Our Ref: EP/46/20/HH

**Town & Country Planning Act 1990 (as amended)
Town & Country Planning (Development Management Procedure) (England) Order 2015
Application for Planning Permission for Works or Extension to a Dwelling**

Development Demolish existing conservatory to rear elevation. Enlarge existing dining room extension to create a new garden room.

Location Dorestan 10 Worthing Road East Preston

Block Plan shows area bounded by: 506515.96, 102755.92 506605.96, 102845.92 (at a scale of 1:500), OSGridRef: TQ 656 280. The representation of a road, track or path is no evidence of a right of way. The representation of features as lines is no evidence of a property boundary.

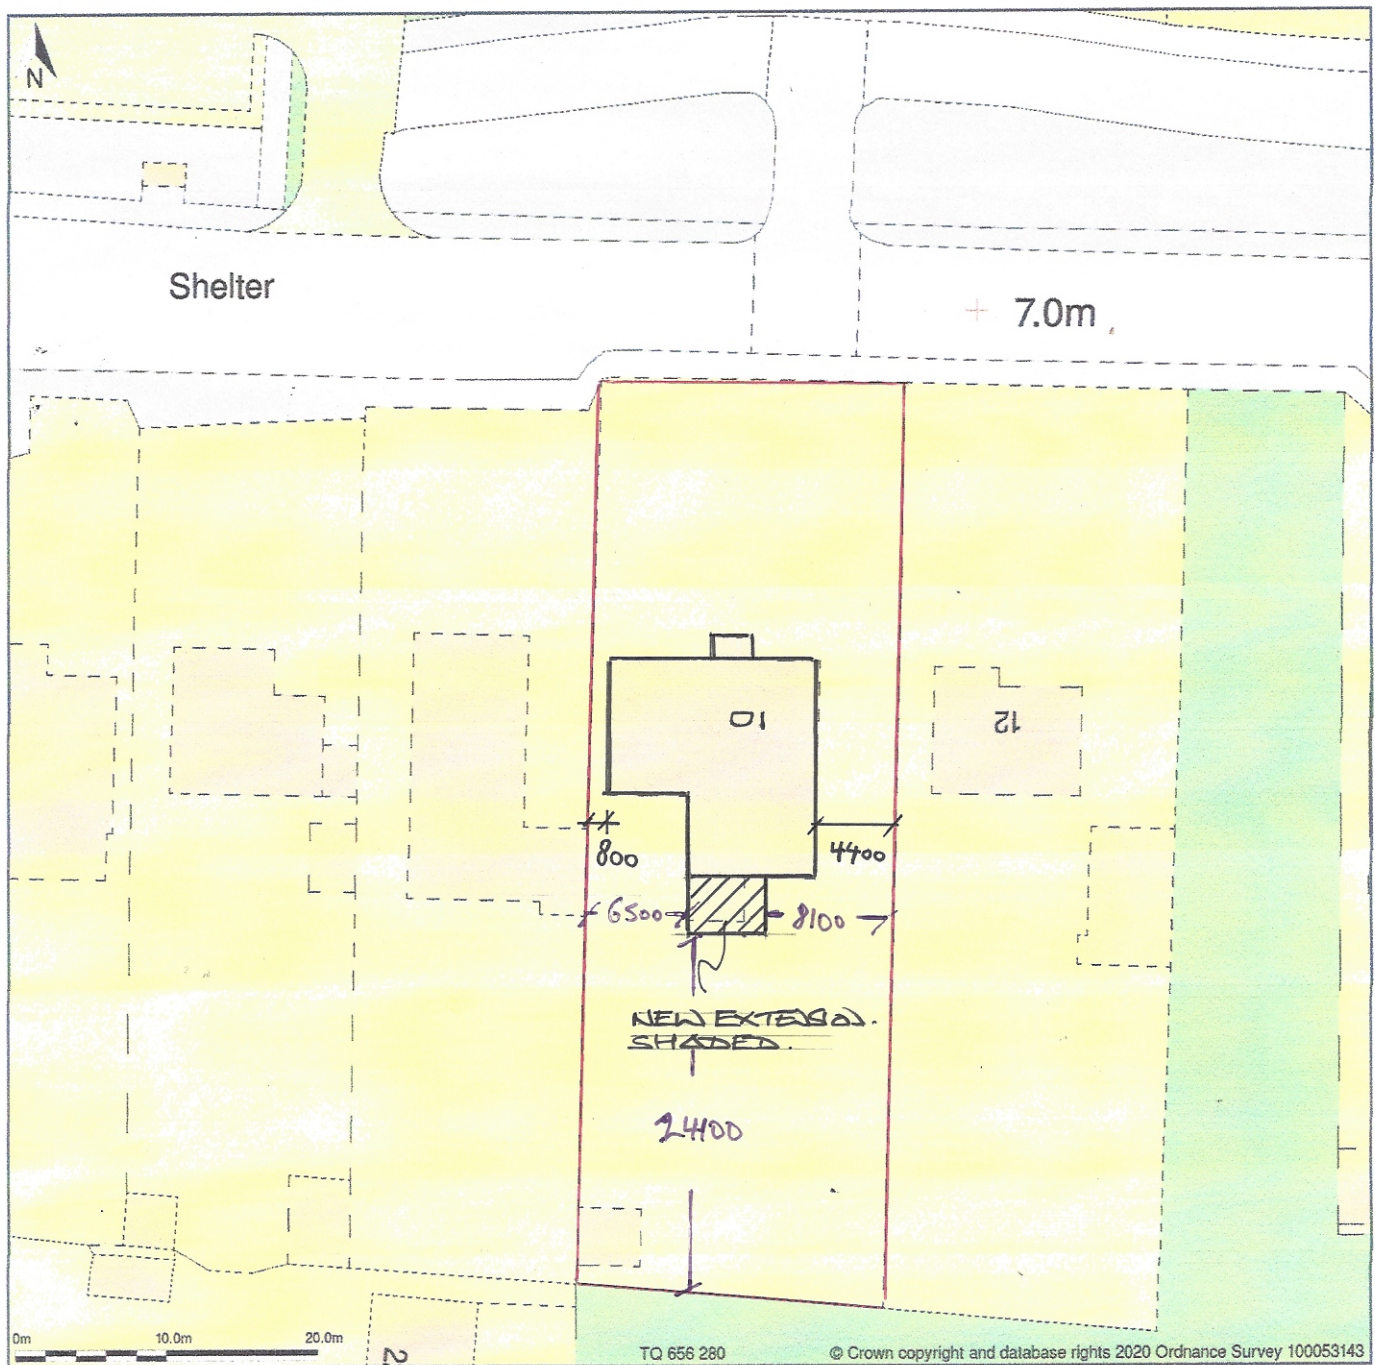
Dimensions: You are required to include dimensions on the block from the proposed extension to all site boundaries.

Proposed Block: The proposed block appears to be showing a new porch. Please clarify and amend the plan.
